September 7, 1995

RE: HELMICK TOWNHOMES (G20/D37) DRAINAGE AND GRADING PLAN FOR
FINAL PLAT APPROVAL. ENGINEER'S STAMP DATED 8/24/95.

GRADING AND DRAINAGE PLAN

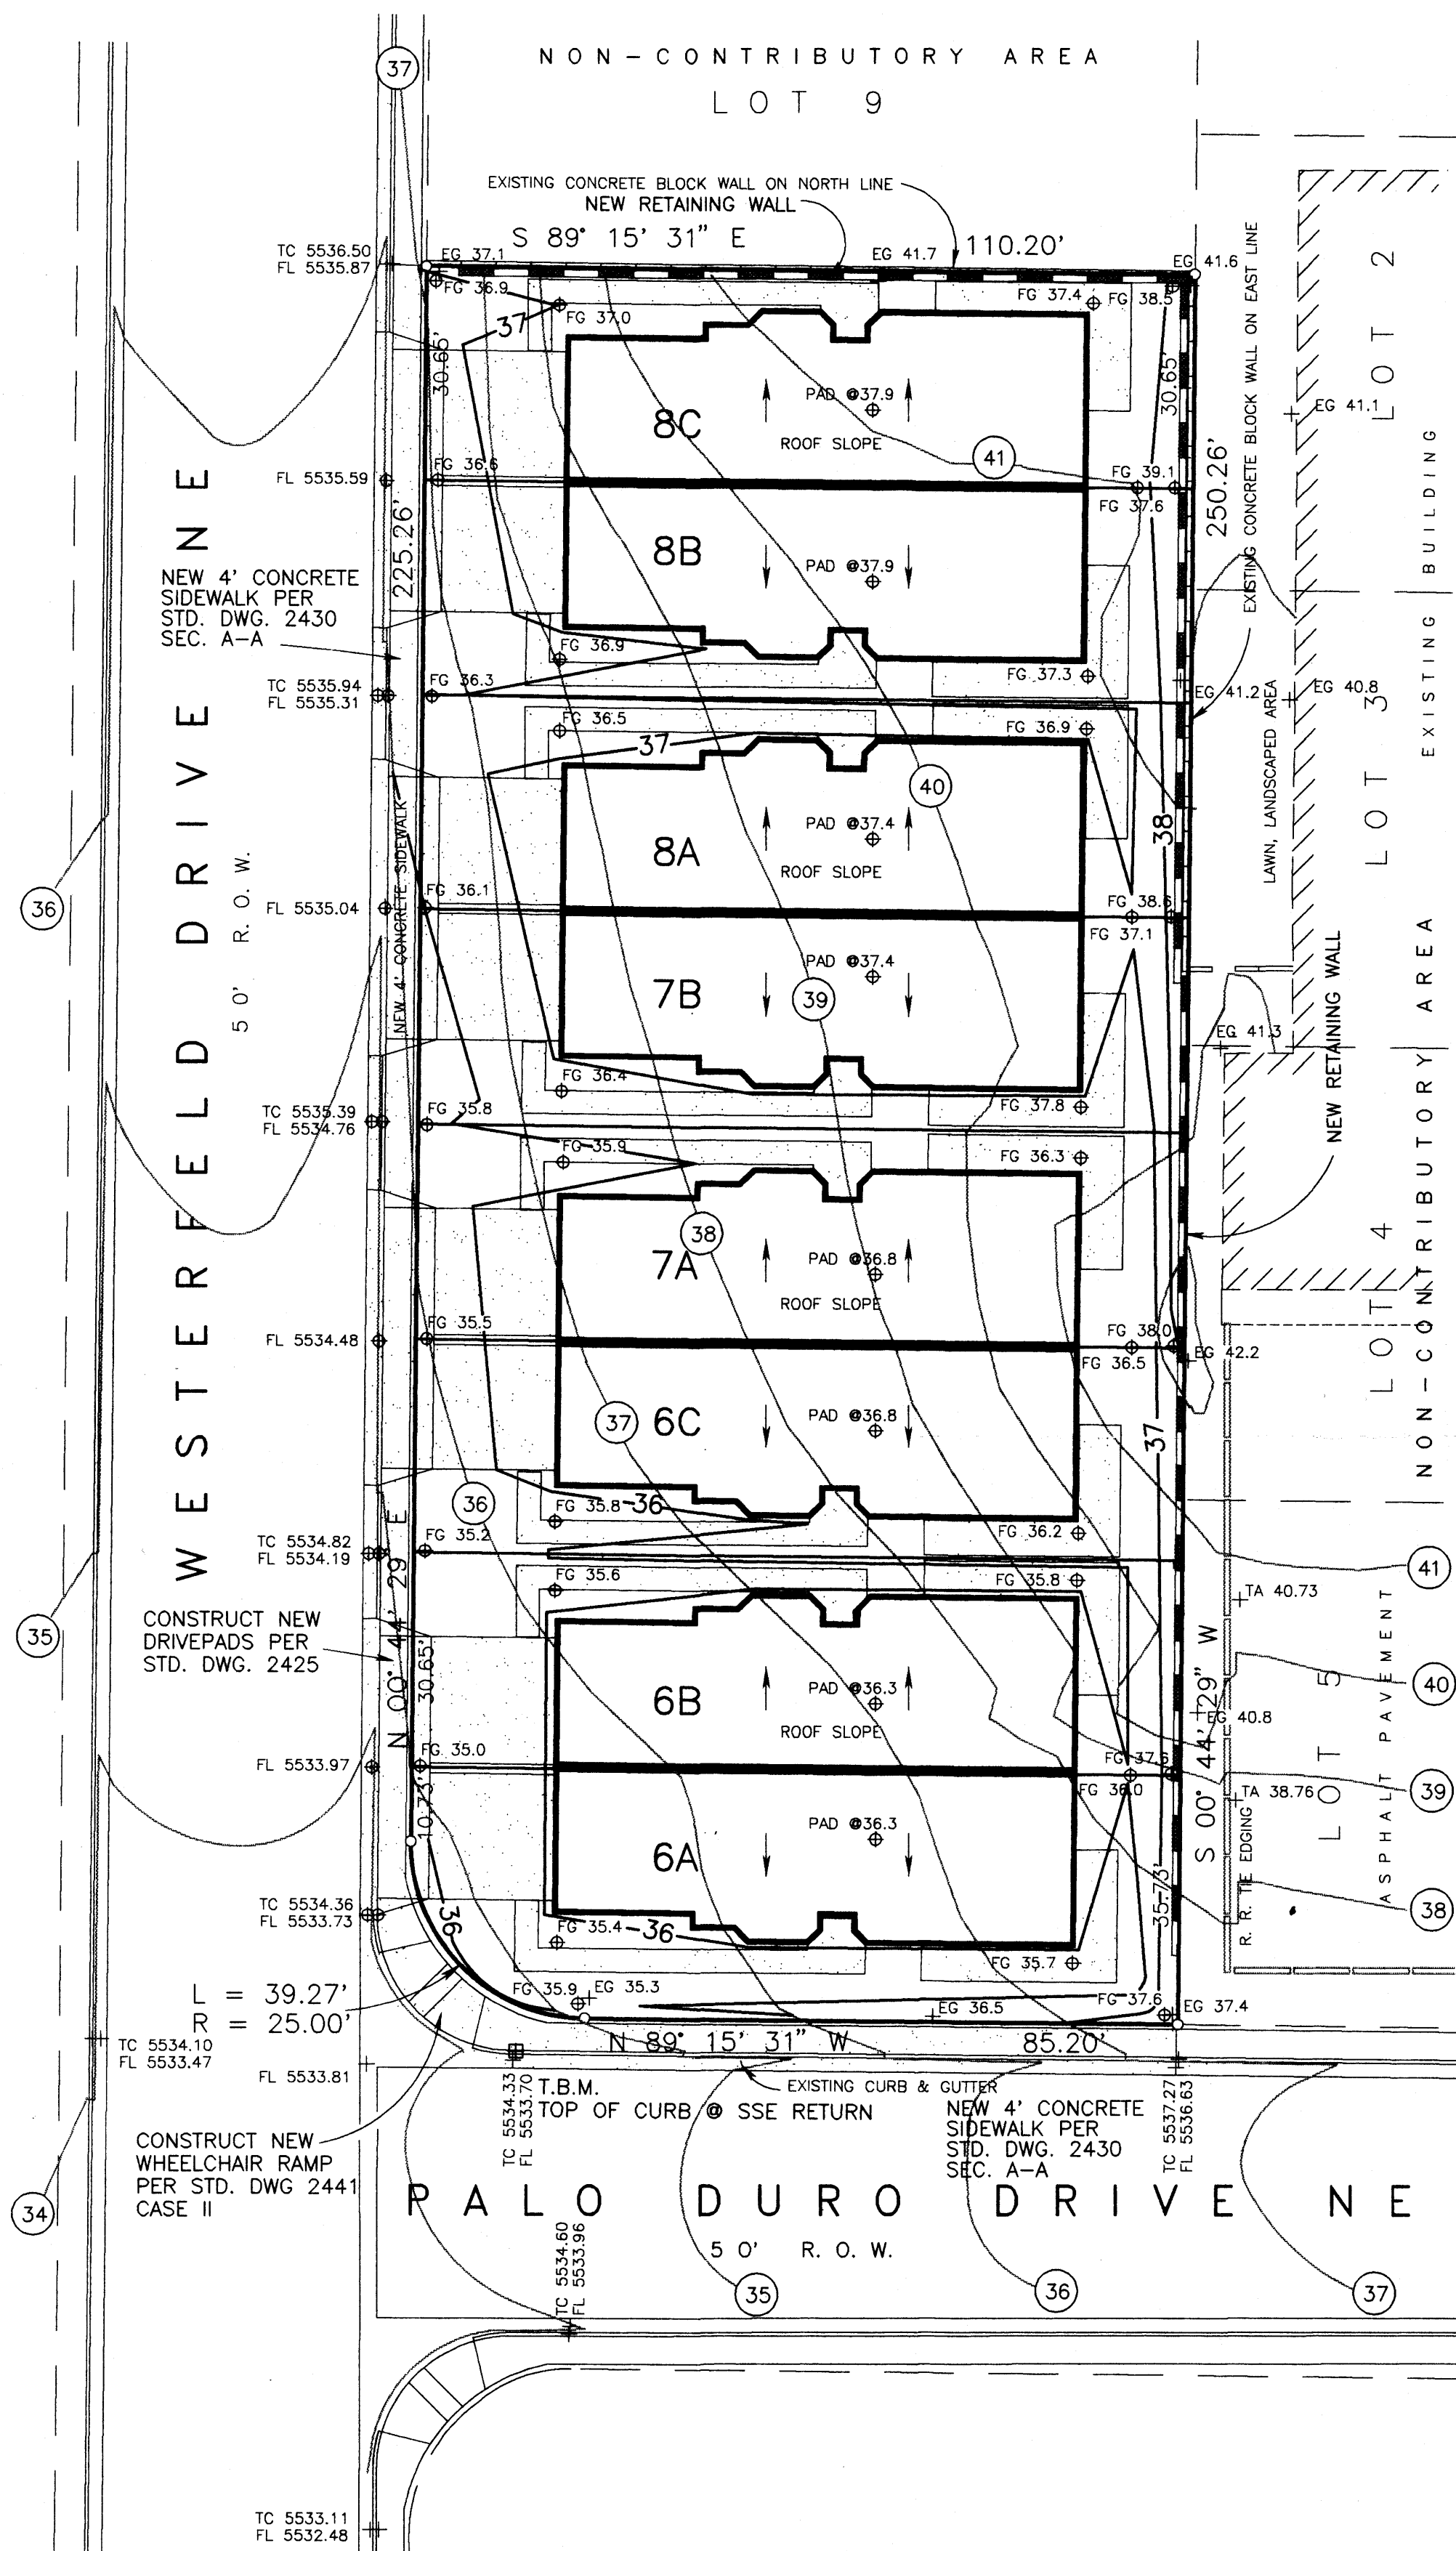
Prior to financial guarantee, the engineer must certify grading and retaining walls were constructed according to approved plan.

Please show finish floor elevation to mean sea level before next submittal.
